DECISION DELEGATED TO HEAD OF PLANNING

Application No: H14-0798-26 **Applicant:** Glen Pastures

Proposal: Siting of 2 containers - one for storage of agricultural machinery, the other for agricultural workers welfare facilities

Location: Glen Pastures Bourne Road Guthram Gowt

Proposed Site Plan

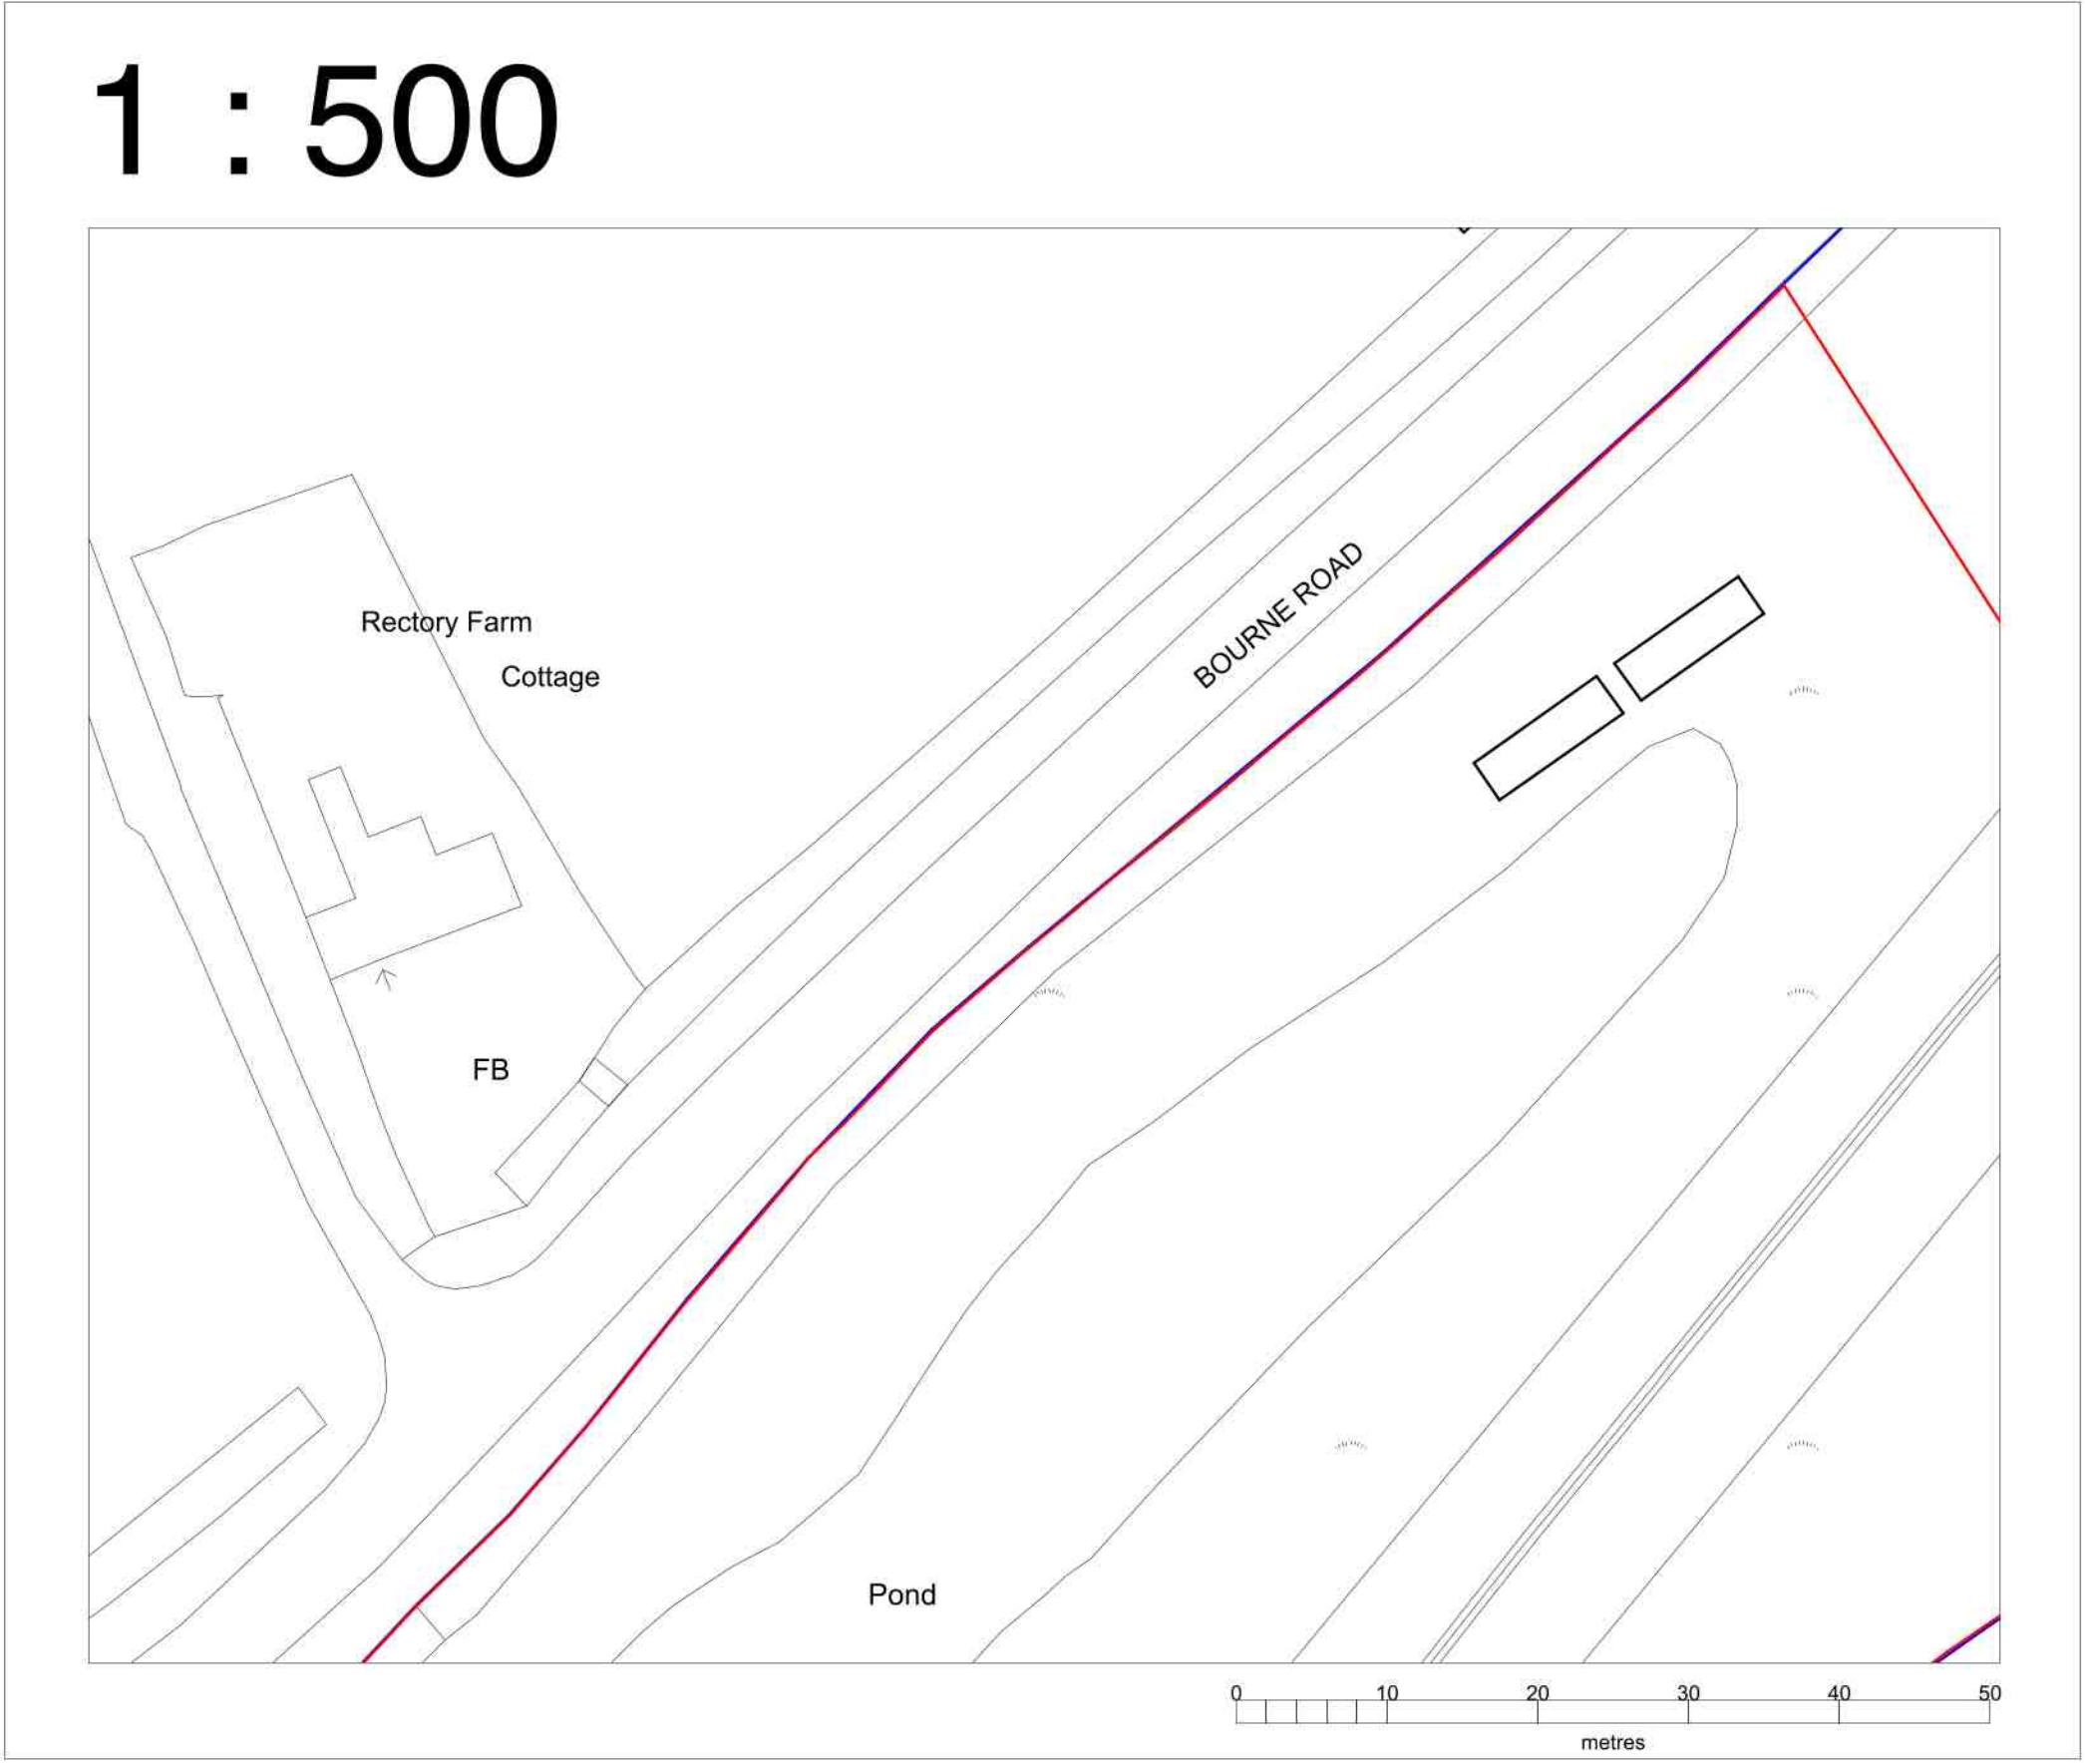
Furthermore, the containers would be located approximately 15m from Bourne Road (the A151) which is a classified road. One of the restrictions of Class A is set out below:

"h) any part of the development would be within 25 metres of a metalled part of a trunk road or classified road;"

The 'metalled' part of the road refers to a hard durable surface such as cement, concrete or tar. As the containers would be less than 25m from the metalled part of the A151, the proposal would not comply with the above referenced restriction.

The applicant has provided an amended site plan showing the containers in an alternative location which would be more than 25m from the A151. Whilst this has been considered, as set out previously, the containers are not considered to be eligible for the Class A permitted development right as the containers are considered to comprise chattels rather than buildings.
